Subject: DOCO comments for application 2026/91186 at land at Merchant Fields Farm, off Hunsworth Lane, Cleckheaton

Re: 2026/91186- Discharge of details reserved by conditions 14 (EV Charging Point), 26 (materials), 29 (landscaping) and 33 (BEMP) on previous permission 2021/92801 for erection of 291 dwellings with associated works and access from Hunsworth Lane and Kilroyd Drive; land at Merchant Fields Farm, off Hunsworth Lane, Cleckheaton

Condition 29- landscaping

title: PLAIN BOUNDARY SCREEN WALL DETAIL

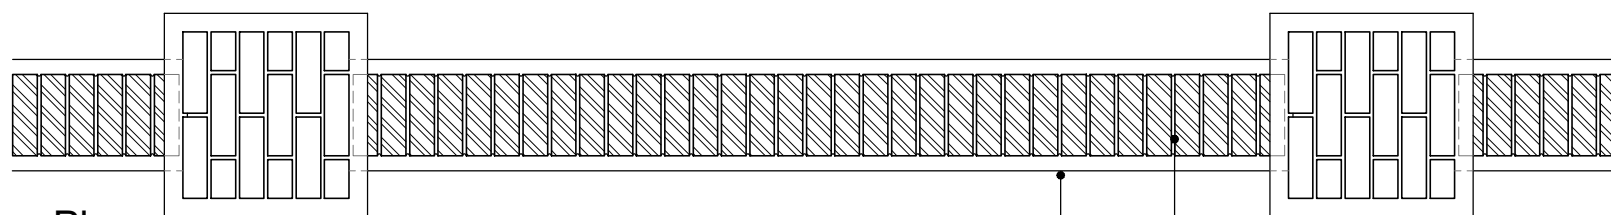
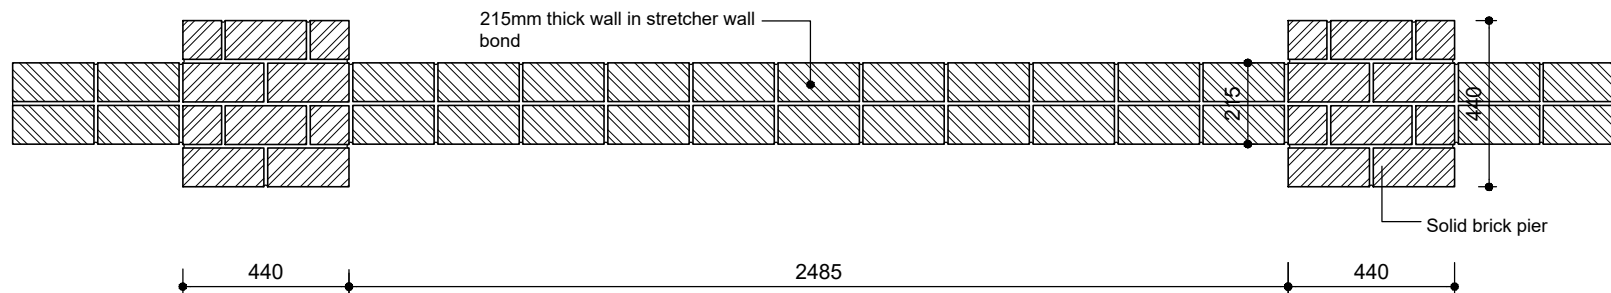
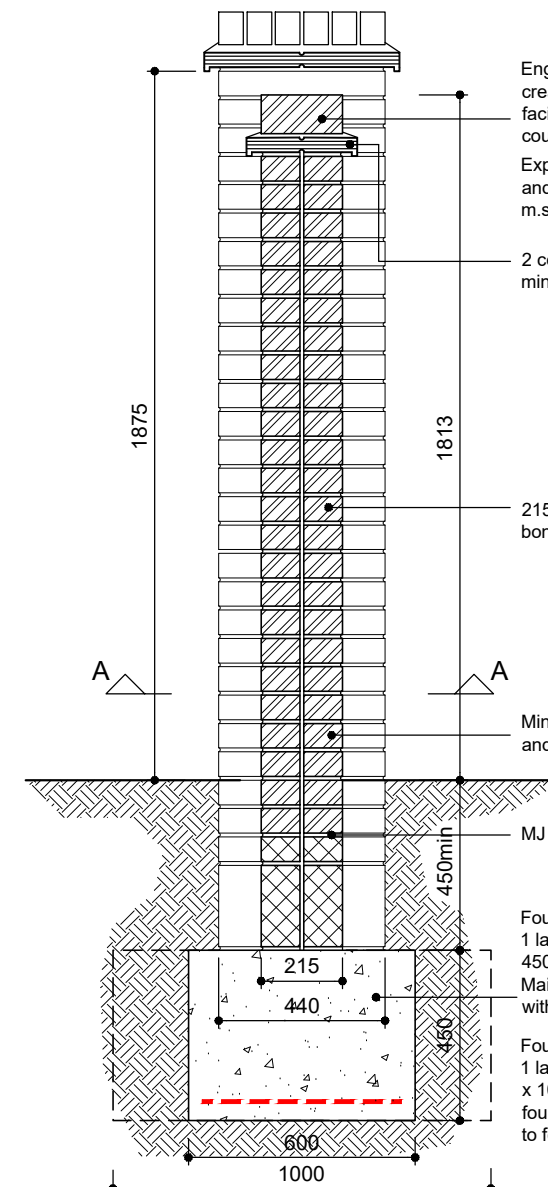
The elevation details of pier and panel wall appear to be missing; however, the listed height is acceptable. Could the applicant please be advised that the infill panels should be located flush to the external face of the wall to deter climbing and its use as informal seating.
